CITY OF ALBUQUERQUE

RE: Presbyterian Paradise Clinic (File: C12D003B7)
4588 Paradise Blvd NW
Grading and Drainage Plan
Engineer's Stamp Date – 9/17/15

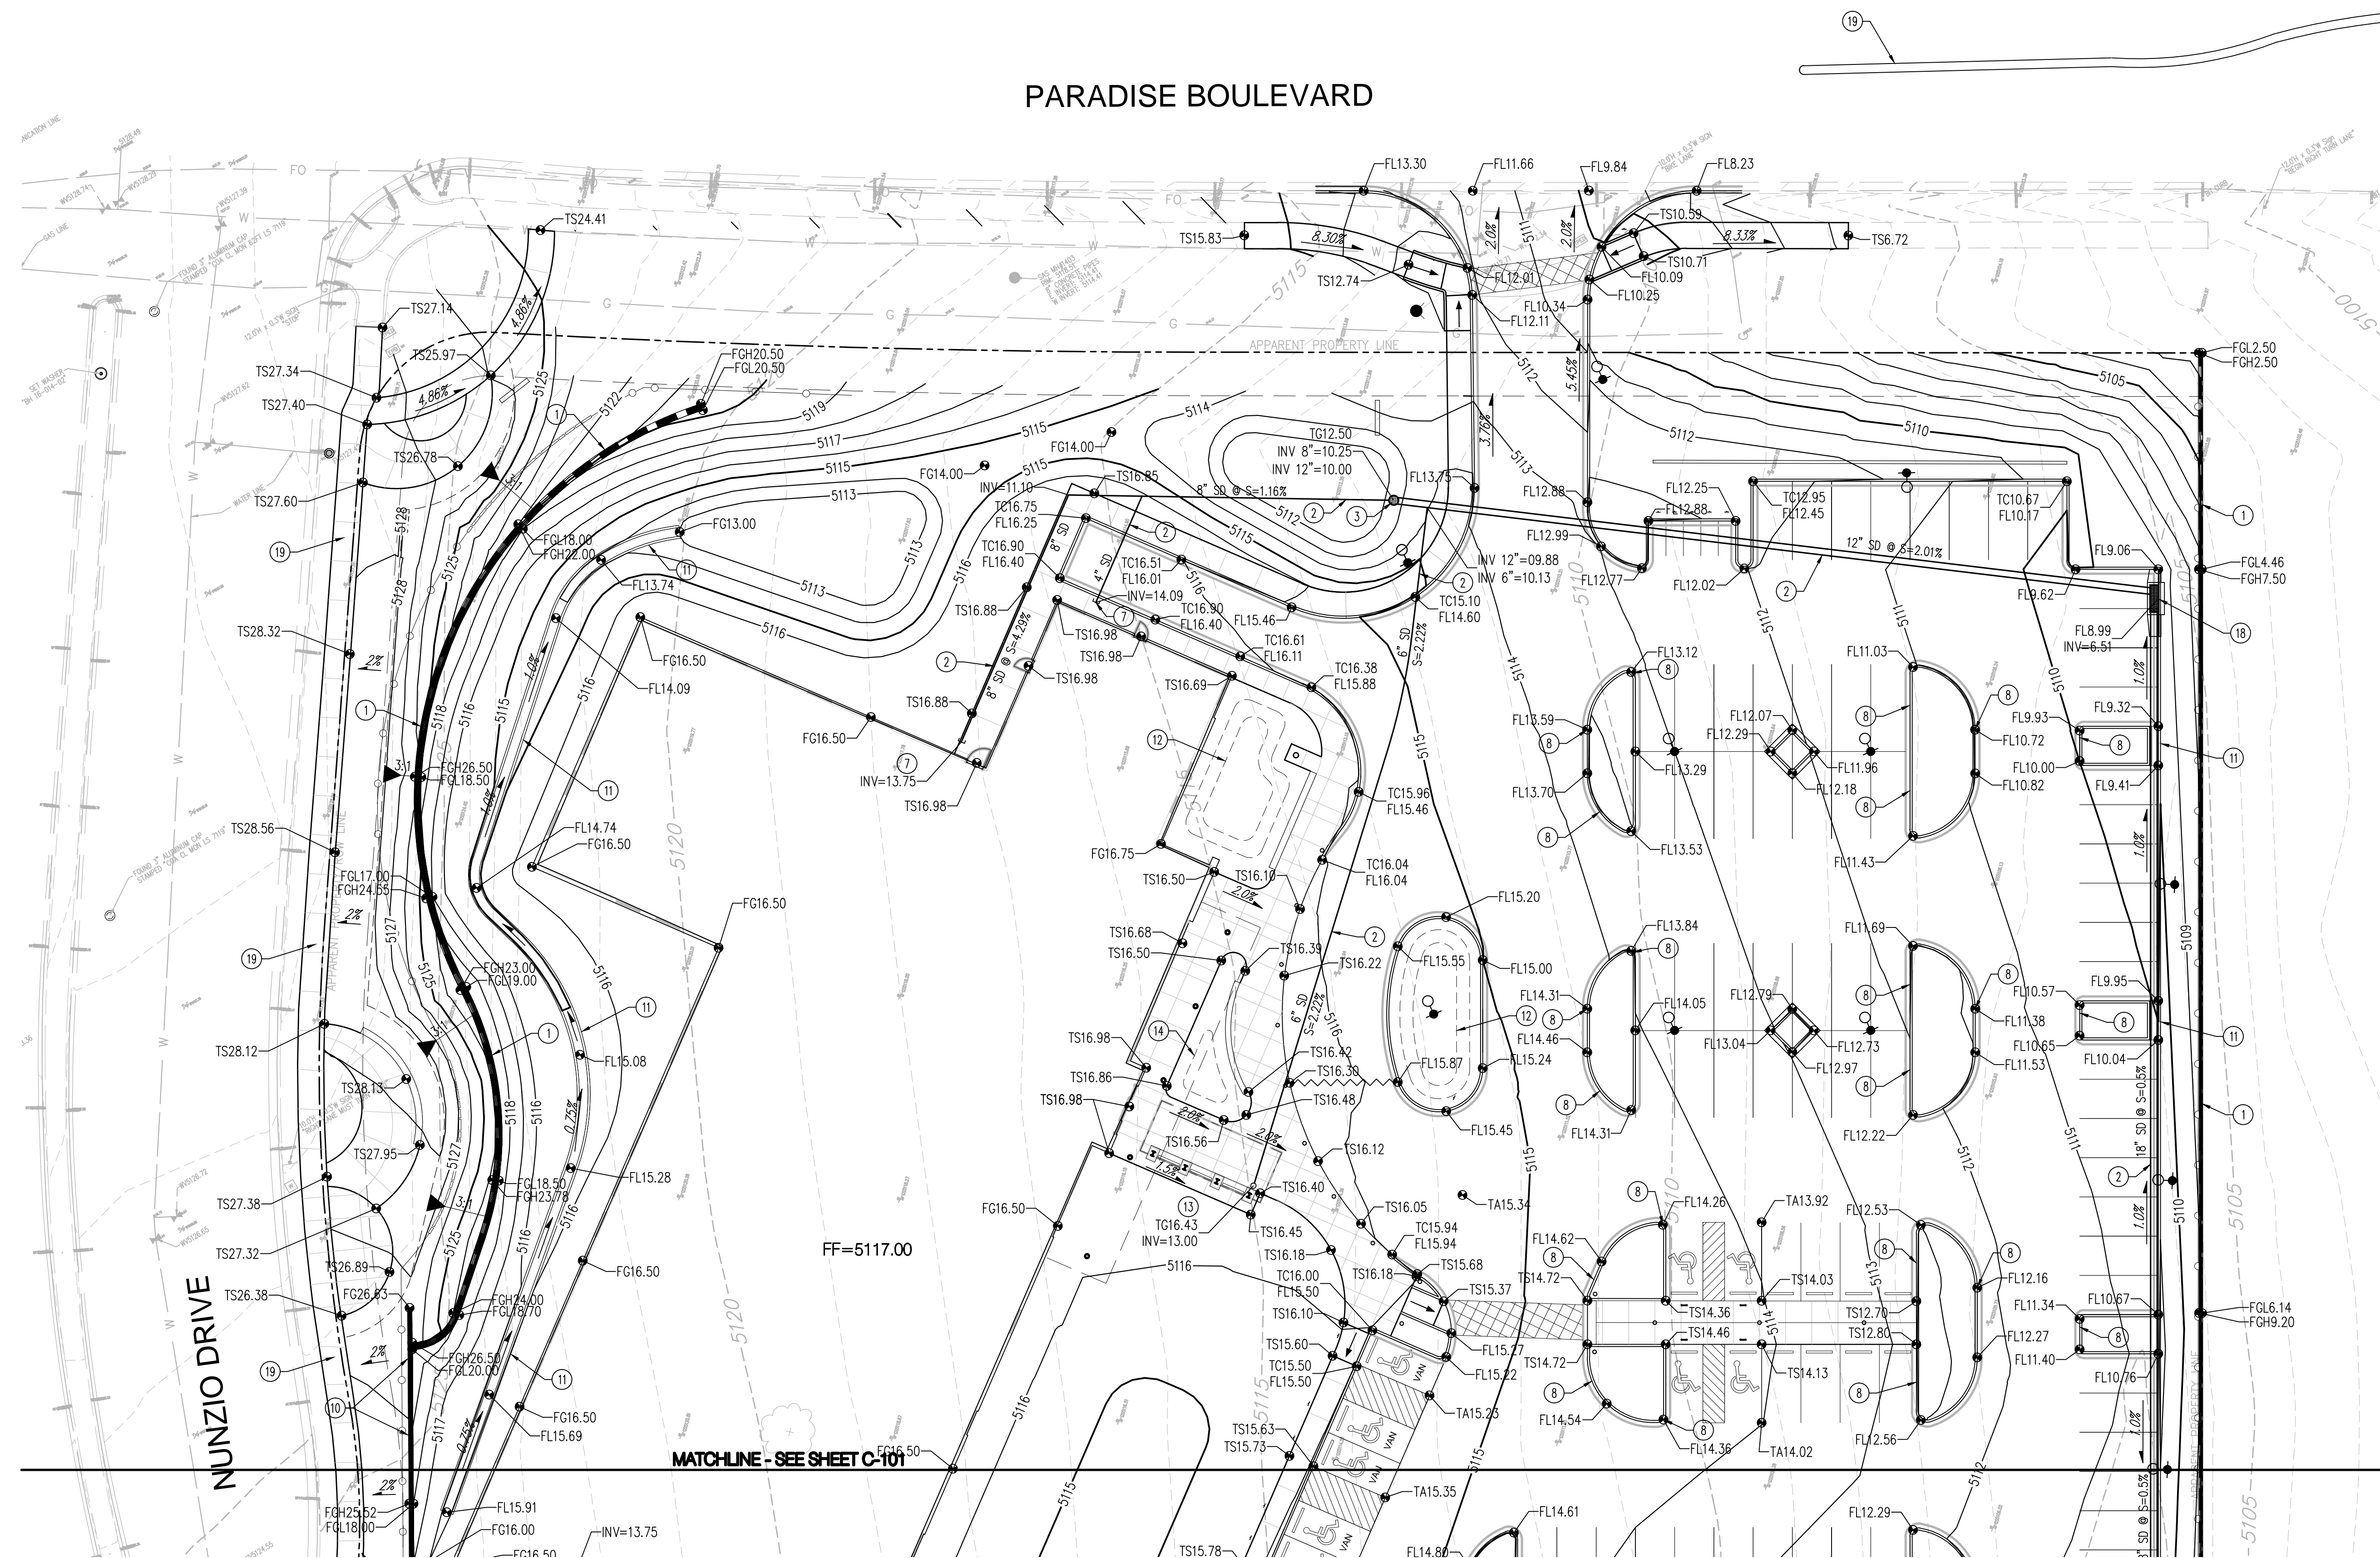
1. Hydrology is allowing the First Flush rainfall depth of 0.44" to be reduced due to initial abstraction, but it is not known if the EPA will agree. Therefore until we are weary of allowing any further reductions due to infiltration. Use 0.34" in First Flush Calculations.
2. Provide License Agreement with AMAFCA.
3. Remove Curb cuts on lowside of parking islands
4. Use a keyed note to call out depressed landscaping and provide a spot elevation. May need to recalculate pond volume.
5. Provide flow arrows for roof discharge.
6. Roof drain 1 to discharge to Pond 1 (NW Pond)
7. Roof drain 2 to discharge to Pond 2
8. Disconnect pipe thru pond 2
9. Note screen walls
10. Clarify grade break on NW of property, along 10' PUE/ROW.
11. Note the cobble swale between Ponds 1 and 2
12. Provide erosion protection at discharge of P4 into Pond 3.
